Response to Submissions report - SSD 7610 New Inner Sydney High School at 242A and 244 Cleveland Street, Surry Hills

Thank you for your email of 10 October 2017 inviting comment on the Response to Submissions Reports prepared on behalf of the Department of Education, for submissions received during exhibition of the Environmental Impact Statement for SSD 7610 for the Inner Sydney High School, 242A and 244 Cleveland Street, Surry Hills.

Doc:
Elevations
West Elevation

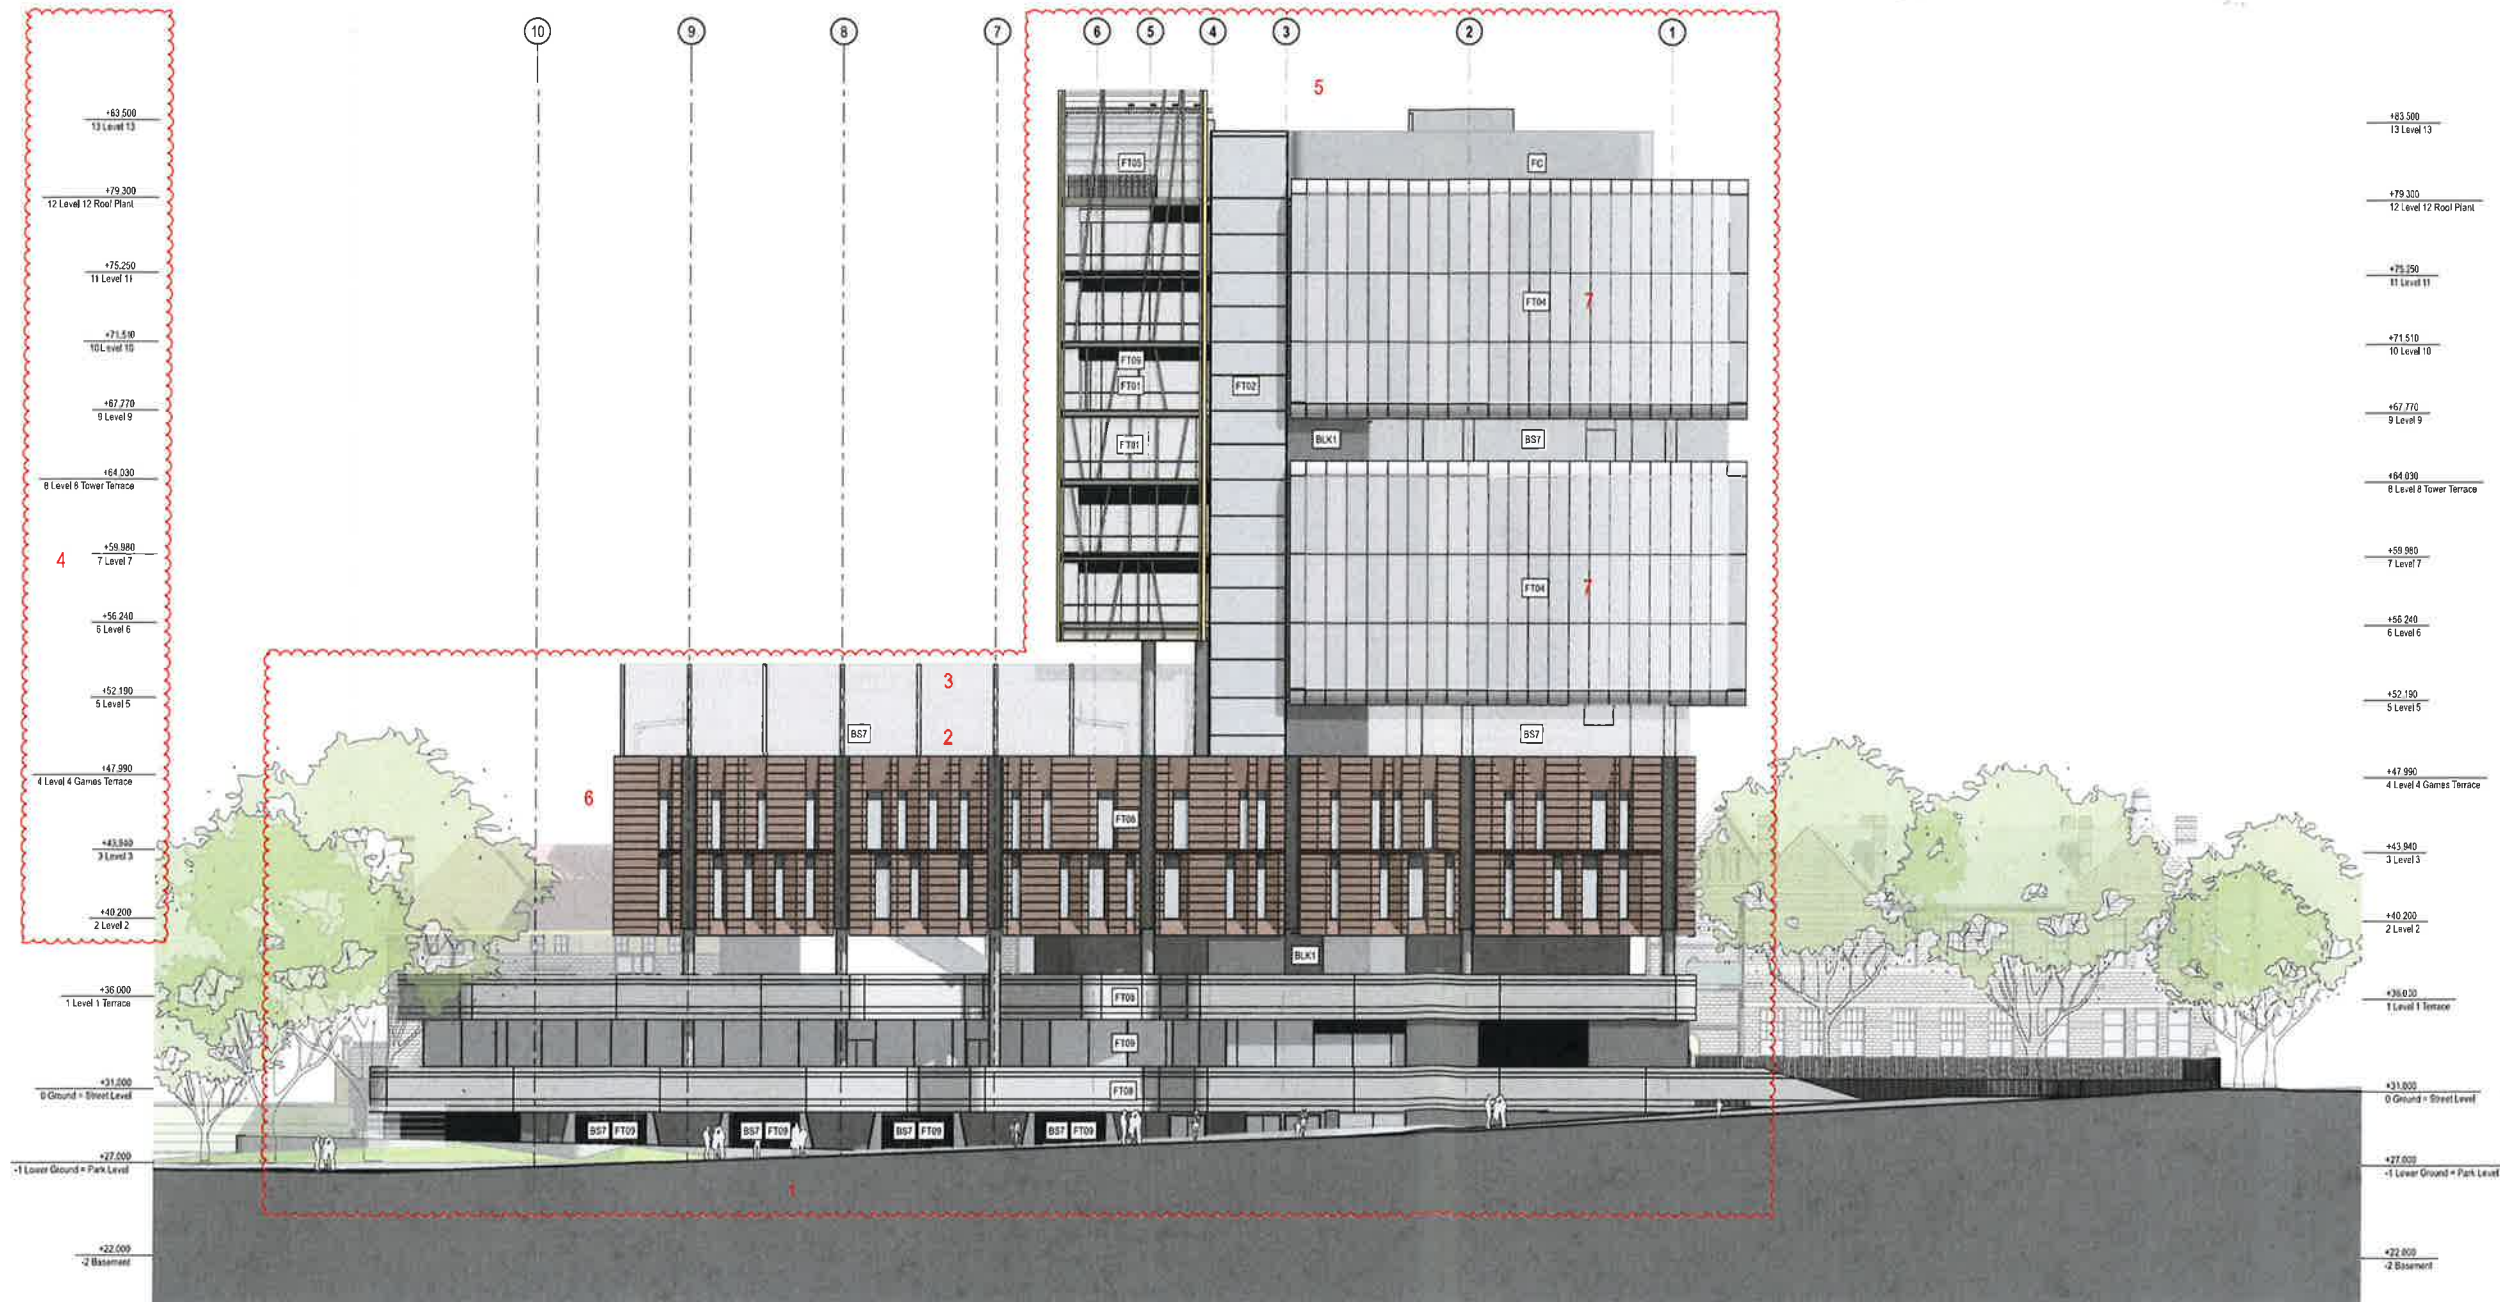
Heritage Council submission 18 August 2017 commenting on the environmental impact statement.	Heritage Council comments on the Response to Submissions reports and amended design.
<i>Proposed tower's height and design are considered to be over-dominant, i.e. intrusive on the school site's scale and setting and also on the adjacent Prince Alfred Park. The tower as proposed will have major adverse visual impact on both, as seen primarily from Chalmers Street and from the Park to the west and north-west.</i>	<p>Despite the amendments to the design, to remove the tower's twist, remove one floor and simplify the composition, the tower's height and design are still over-dominant, and visually intrusive. The amendments are not sufficient to reduce the adverse impact on the setting and view to the significant buildings of the Former Cleveland Street Public School.</p> <p>The proposed tower is over-dominant and visually intrusive because its composition is over scaled and overly complex for this site. The tower comprises strong over scaled elements, stacked glazed boxes on pilotis, a glazed vertical shaft and a random battened glazed box. The tower's large-scale elements are almost indifferent to the existing historic buildings' smaller scale and picturesque composition. The arrangement is too busy and the large scale will upstage the visual prominence of the historic</p>

school buildings seen from the street, the park and in the round.

The tower's composition and its variety of materials should be simplified much further, so it does not upstage the historic buildings. The tower's level of simplicity should be guided by the success in the simplicity of Charles Perkins Centre at the University of Sydney also by FJMT which is placed alongside, but has not upstaged the sandstone clad St John's College, its historic neighbour. Refer Figure 1 below.

West Elevation
1:200

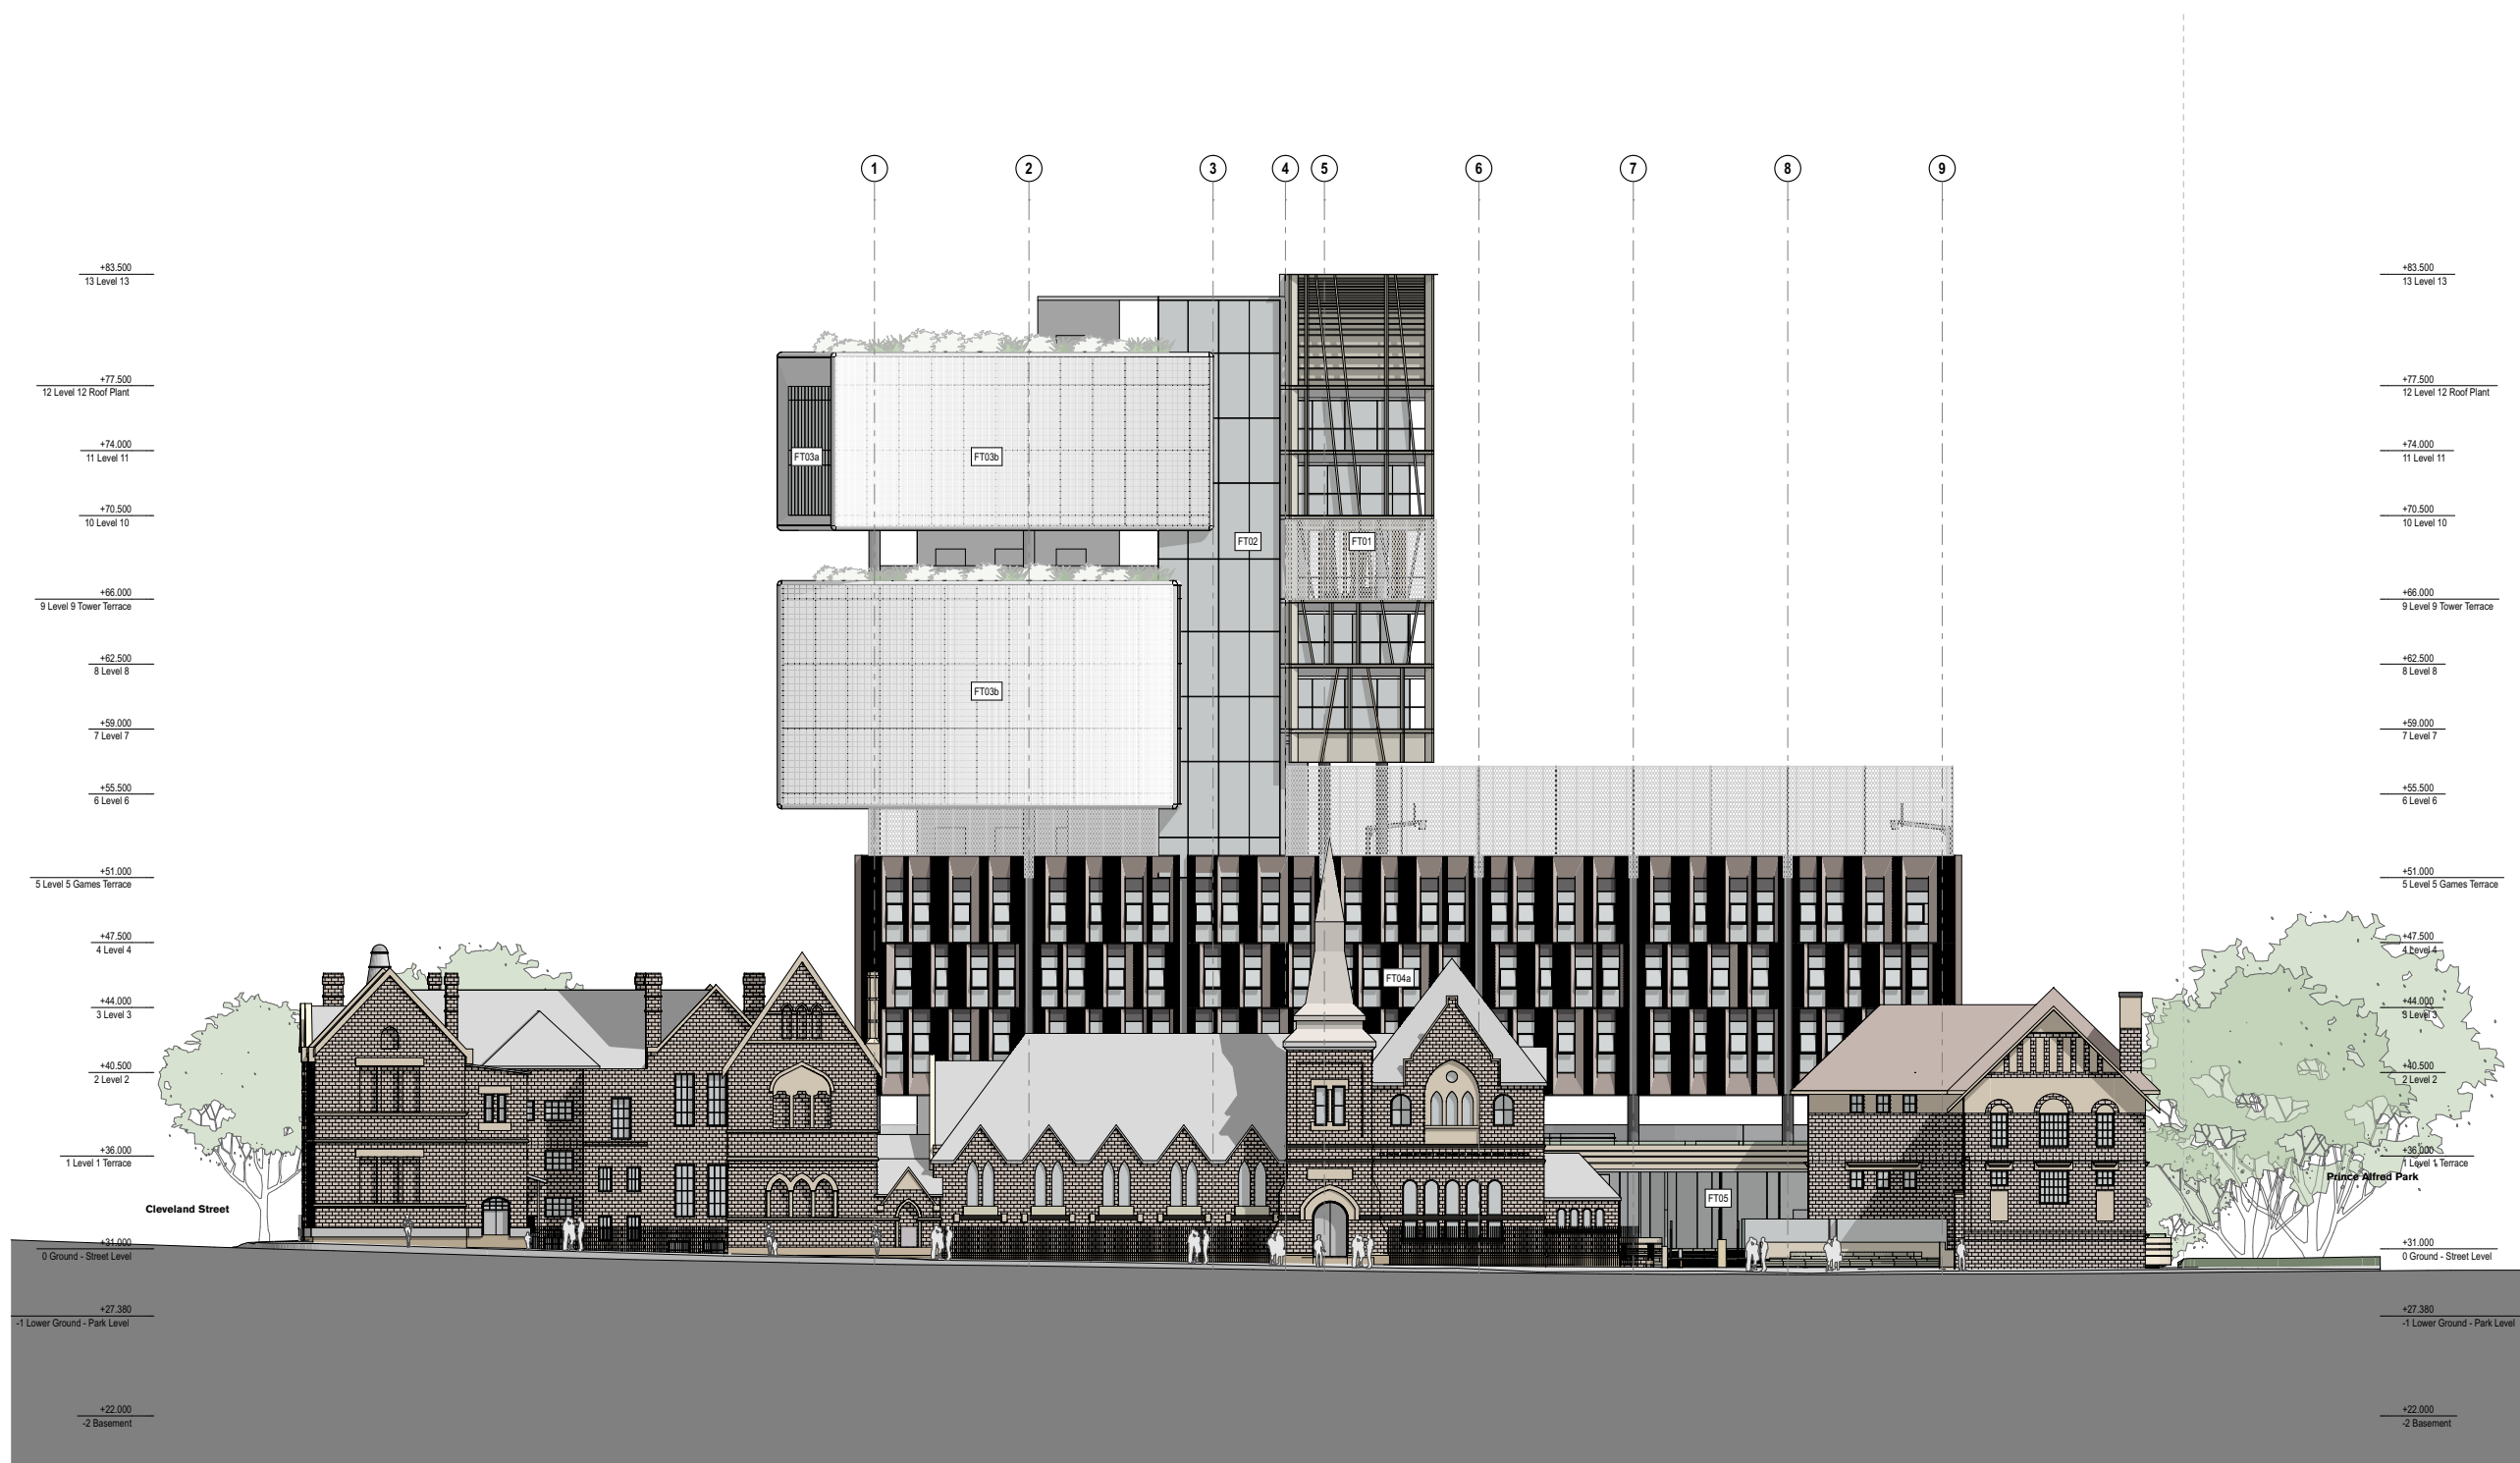
Also, the simplicity of the exterior of the new building's studio floors is successful. In contrast to the tower's busyness, the studio floors, with their precast cladding, are more uniform, simpler and quieter, but no less contemporary. The studios are a more respectful backdrop to the historic school buildings, Figure 2, with visual variety worked into the smaller details not into the large-scale composition.

City of Sydney's 15 August 2017 comments for the environmental impact statement, that the variations in the tower's in external finishes may help to break up the scale, but they create complexity in appearance and possible visual clutter is supported.
